CLEVE HILL SOLAR PARK

STATEMENT OF COMMON GROUND BETWEEN THE APPLICANT AND NATURAL ENGLAND

August 2019
Revision A

Document Reference: 12.2.4
Submitted: Deadline 4

Wintering Bird Noise Threshold
Figure 1

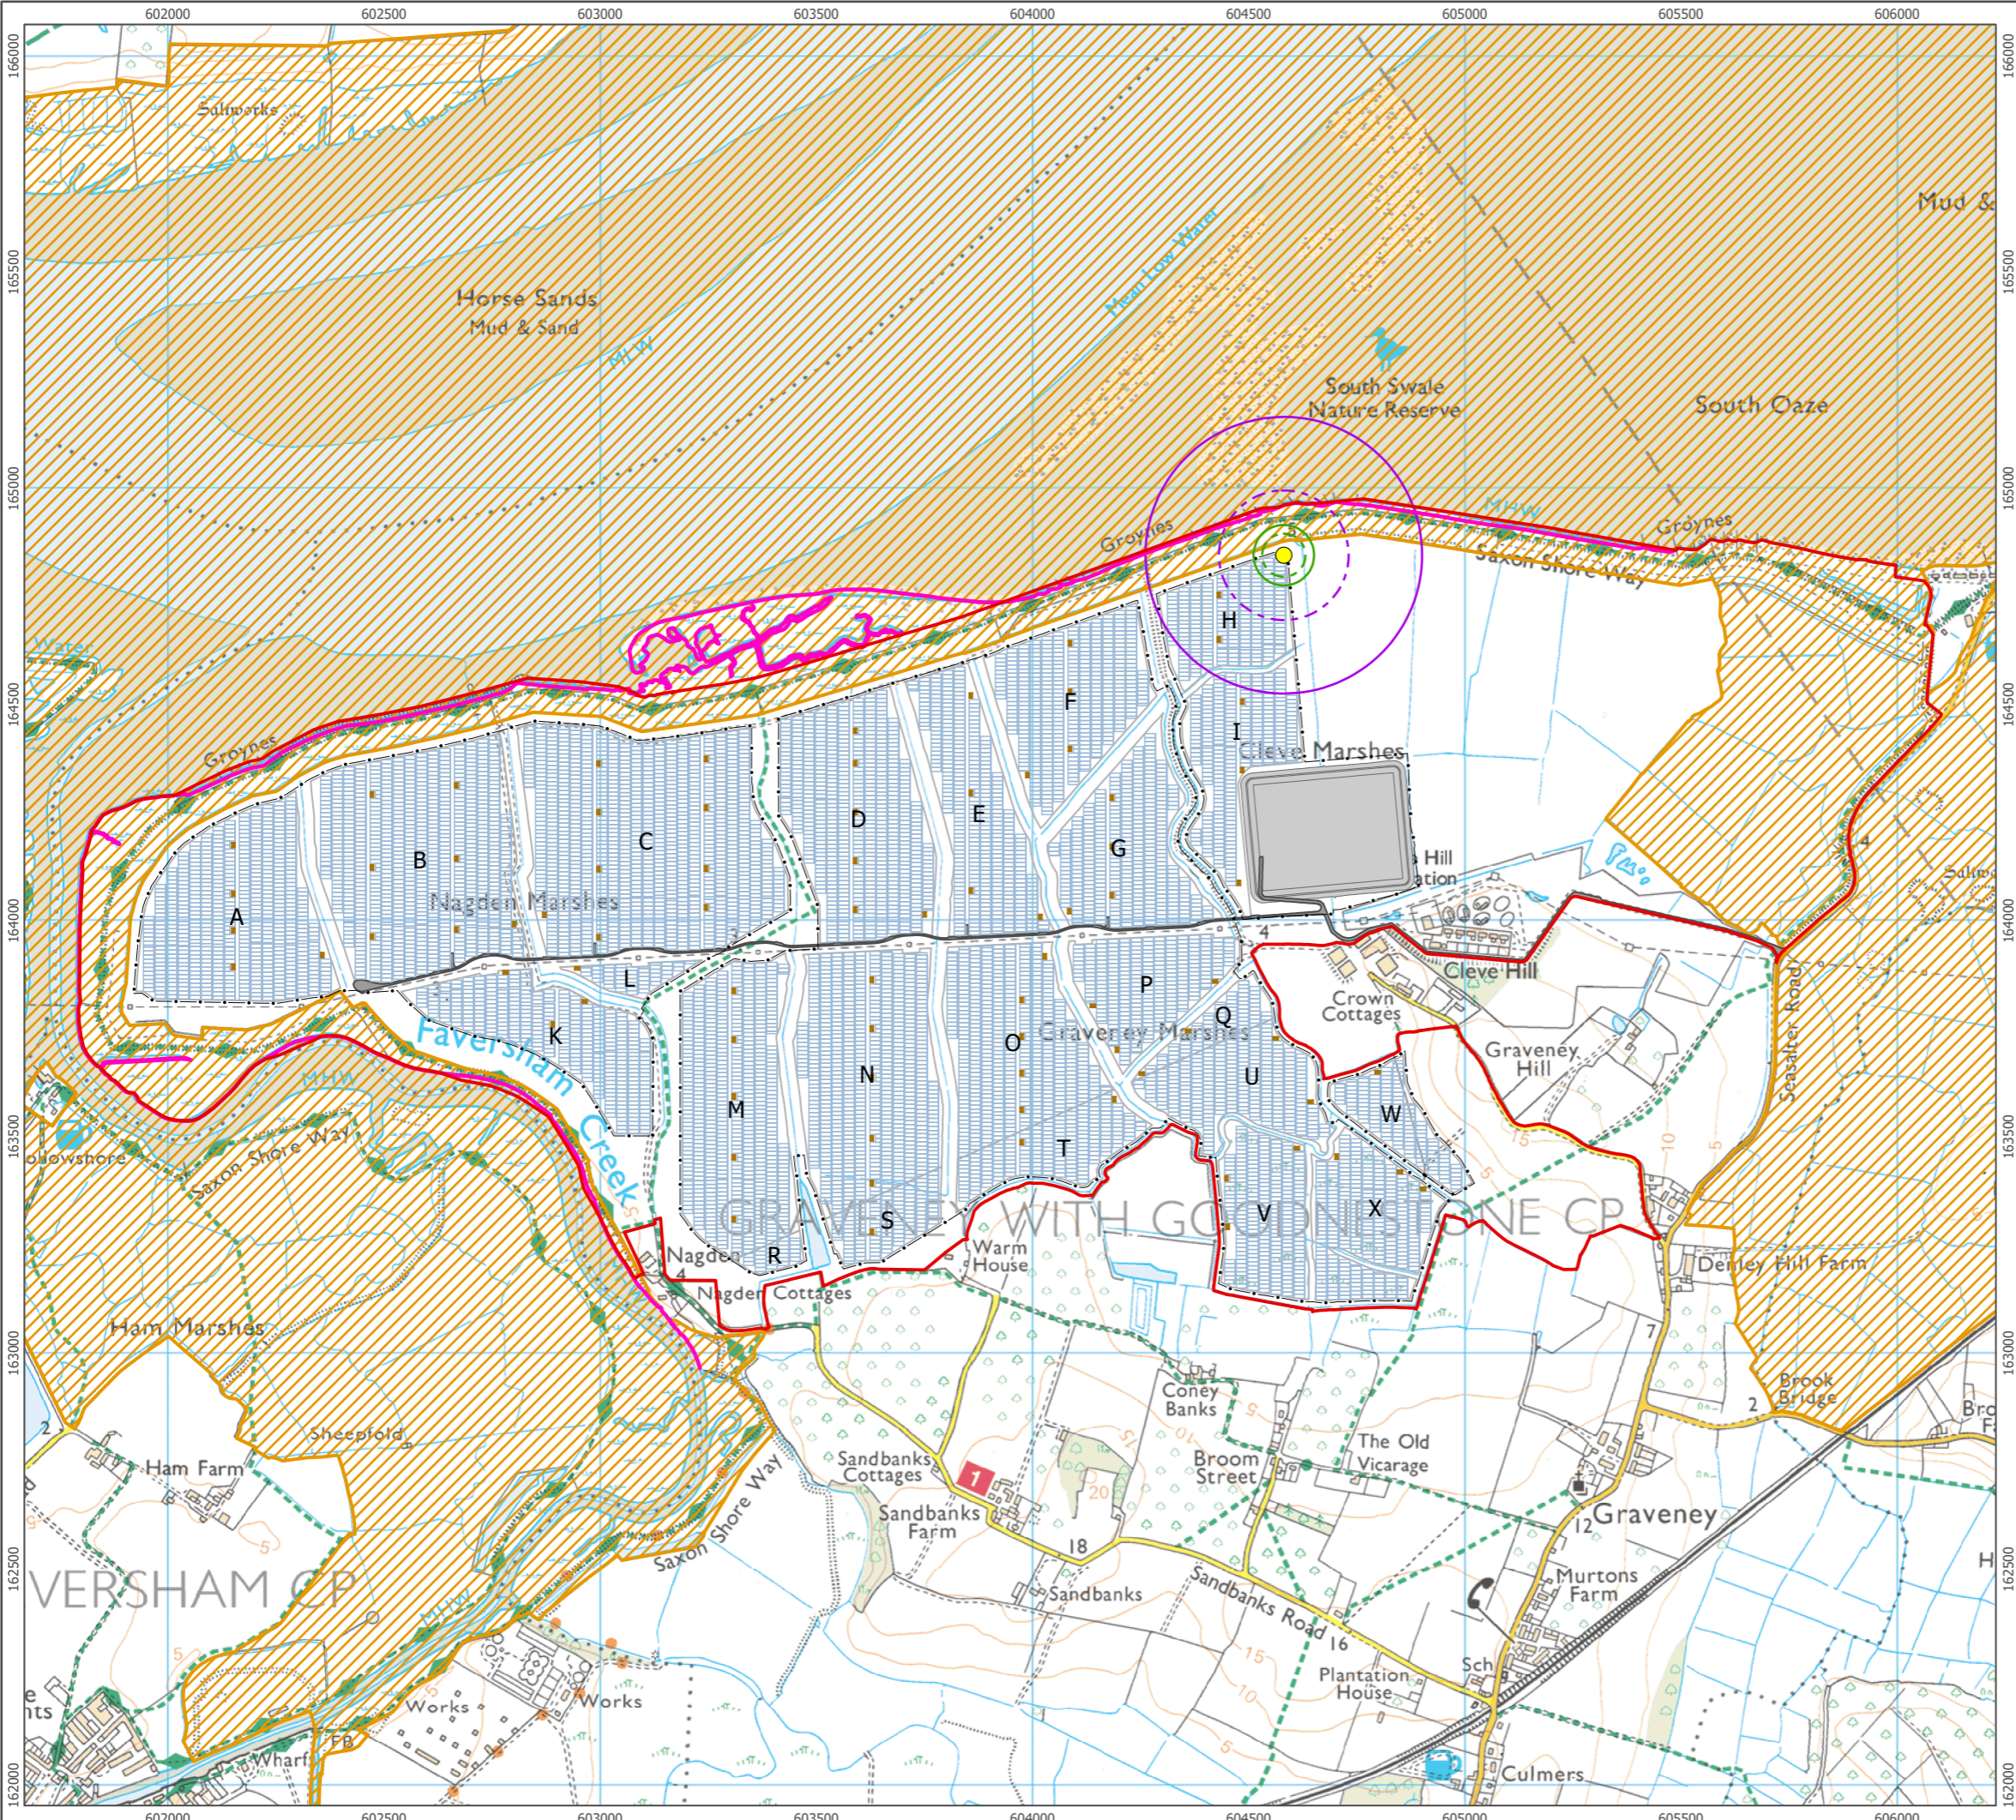
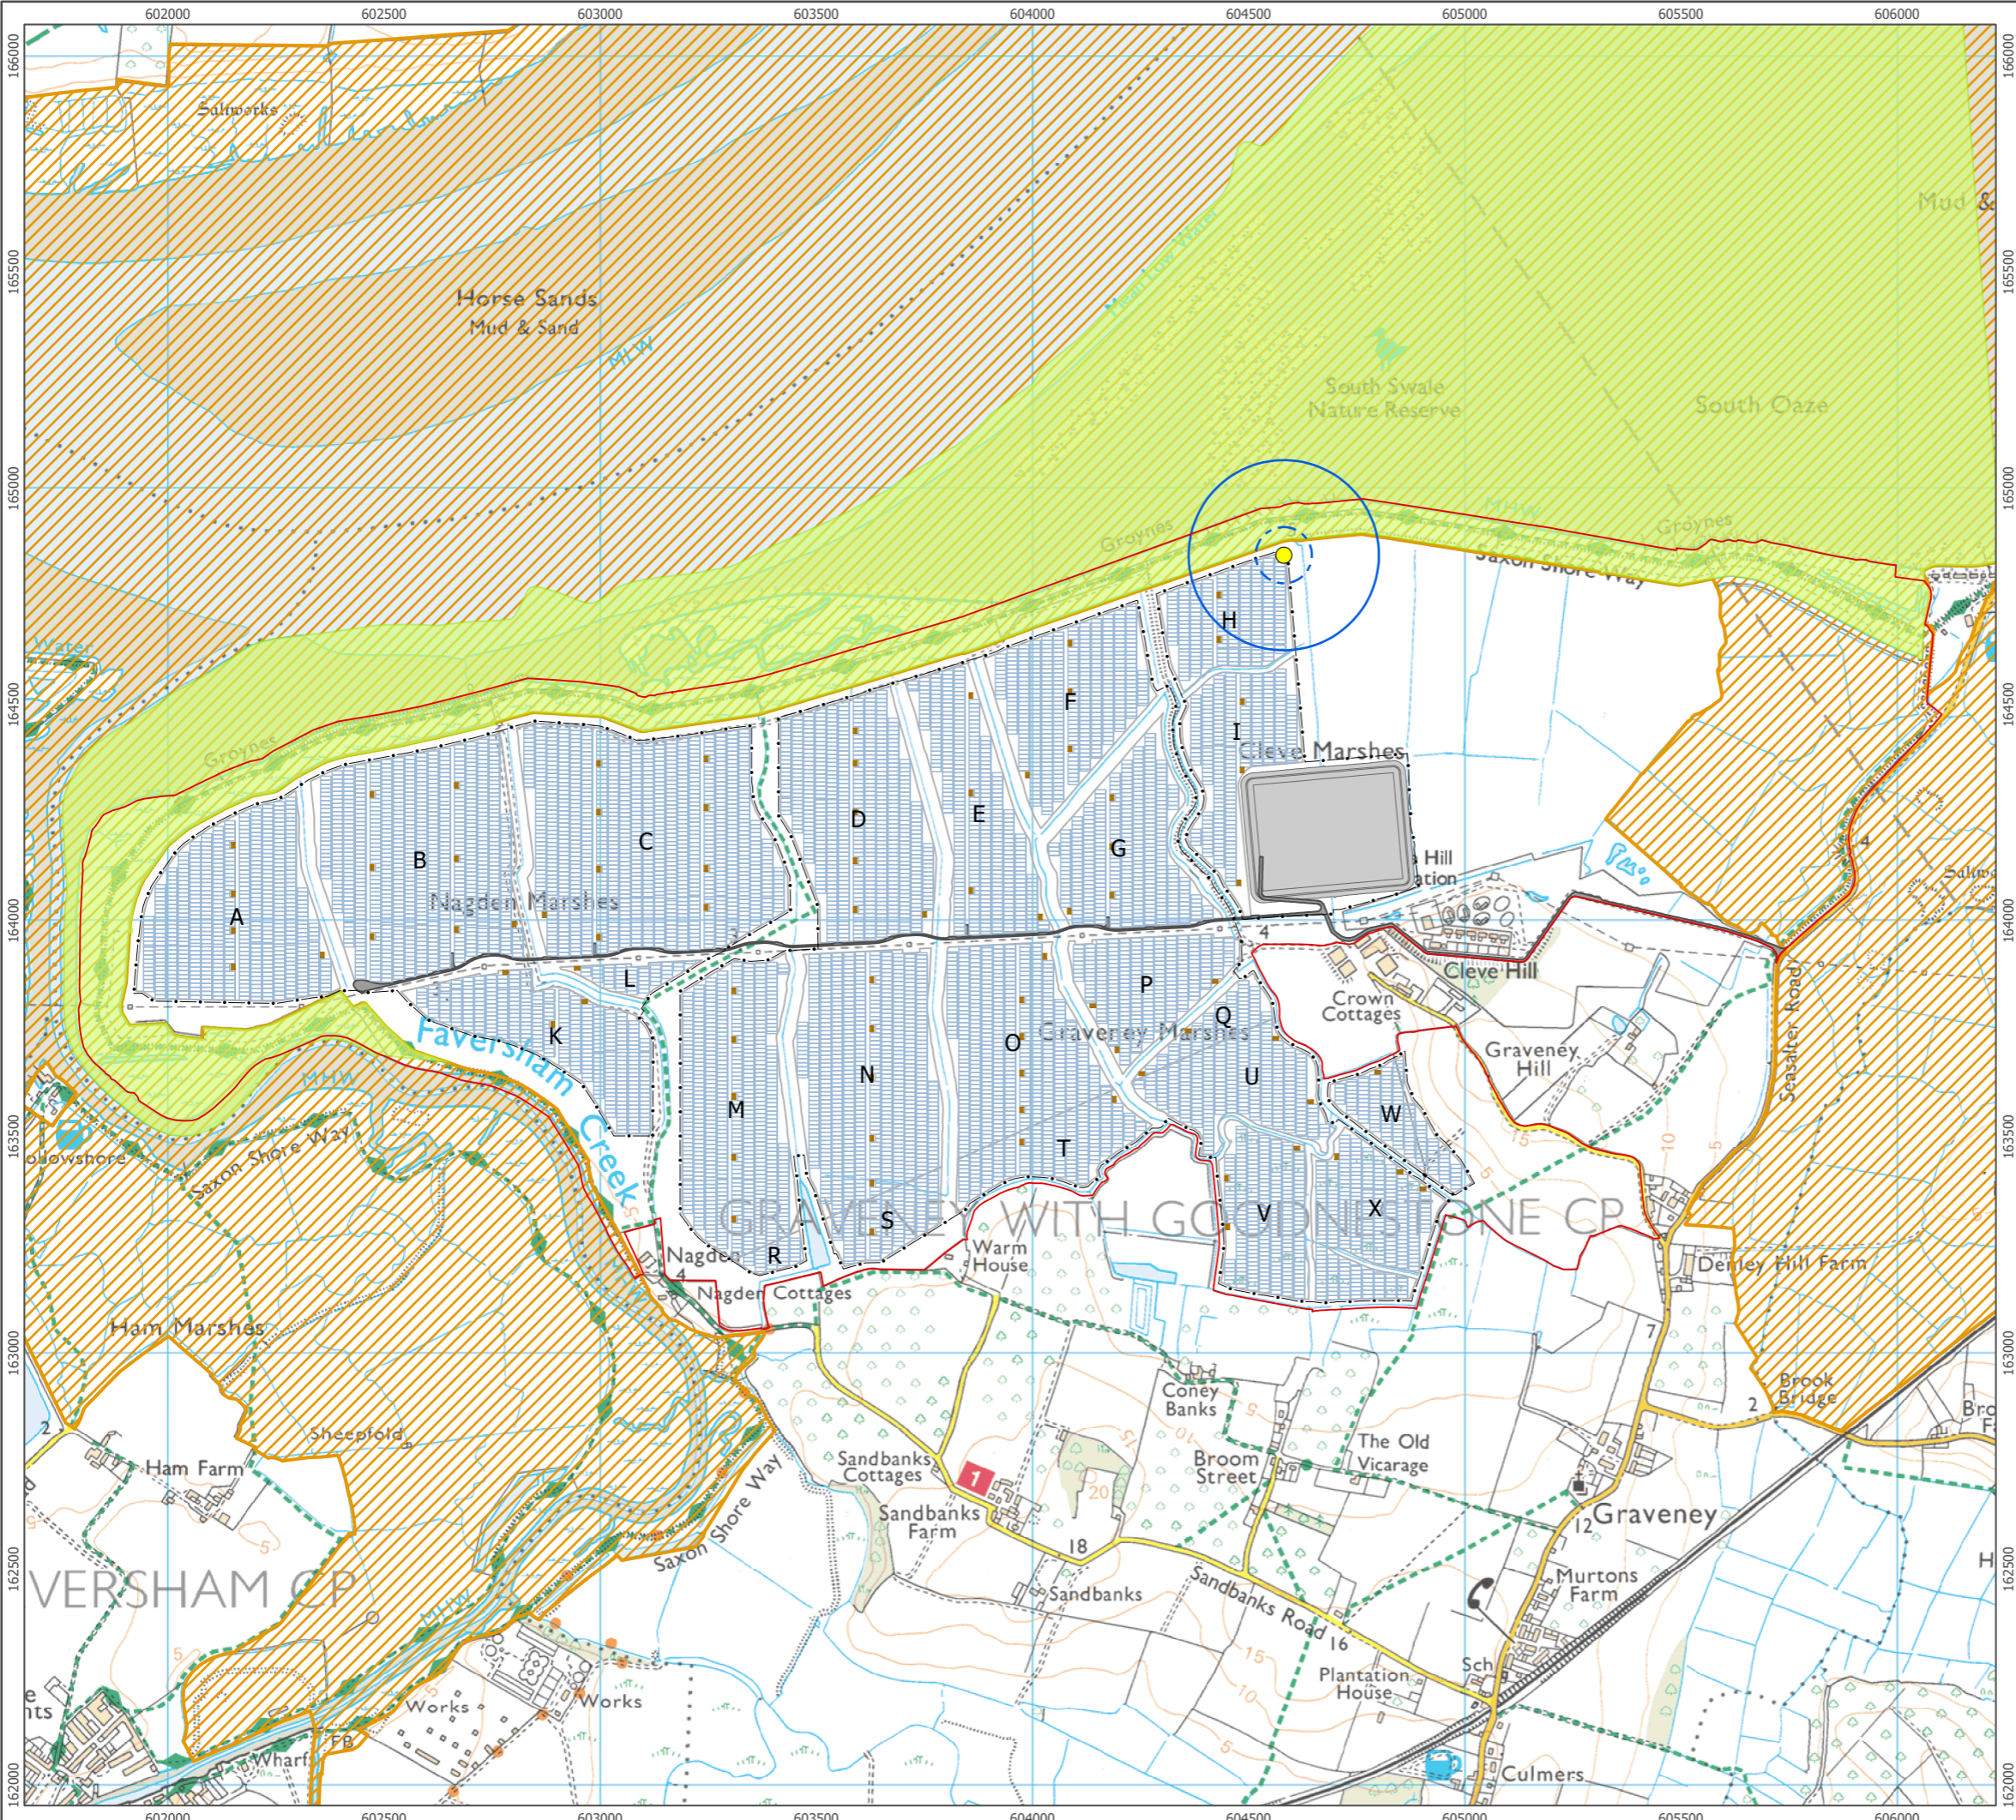
Natural England Comments	Applicant Comments	Status (NE to complete/update)
<p>Figure 3 in the RIAA shows that the 70dBLAmax noise contour does not reach the intertidal area. However, the 55dBLAmax contour extends 320m from the source of the piling, and hence extends into the intertidal. Therefore, there is the potential for wintering birds to be impacted. Natural England recognises that only a relatively small proportion of the SPA is affected (paragraph 134 of the RIAA states that 10.6ha of intertidal habitat will be affected when the piling occurs closest to the SPA), and our view is that at low tide this is unlikely to result in an adverse impact. However, the birds of the SPA are more susceptible to disturbance at high tide when they are roosting, as they are confined to smaller areas closer to the source of disturbance and have fewer alternative sites. Therefore, whilst we welcome the mitigation measures set out in the Outline SPA Construction Noise Management Plan (CNMP), we would like to explore whether timing the piling work closest to the SPA, and in particular, close to Castle Coote, outside of high tide, would be possible.</p>	<p>The Applicant will continue to work with Natural England and the Habitat Management Steering Group (HMSG) to reach a satisfactory and workable construction plan to minimise disturbance to roosting birds in the SPA.</p> <p>The outline SPA CNMP (Examination Library reference APP-243) states that the noise levels will be reassessed when plant and manufacturer data become available to ensure that the mitigation mitigates significantly disturbing activity. At such time, additional protections may be included in the SPA CNMP to minimise the risk of significant disturbance to roosting birds in the SPA. Discussions with the HMSG to date have included suggestions such as timing piling works in areas closest to roost sites at Castle Coote during September/October to avoid the core winter season when birds might be more sensitive to disturbing effects, as well as avoiding disturbance within the SPA during the breeding season. Such areas can be defined as the SPA CNMP evolves once more certain data on noise emissions of plant becomes available.</p> <p>The Applicant seeks agreement from Natural England that this approach provides suitable mechanisms to avoid significant disturbance to roosting birds in the SPA.</p>	<p>NE welcomes the inclusion of specific measures in the updated SPA CNMP [REP3-008] to avoid disturbance to wintering birds using Castle Coote, and breeding birds within the SPA. In particular, Appendix 3 showing indicative setback distances, is helpful. We agree this provides a suitable mechanism to avoid significant disturbance to roosting and breeding birds within the SPA.</p>
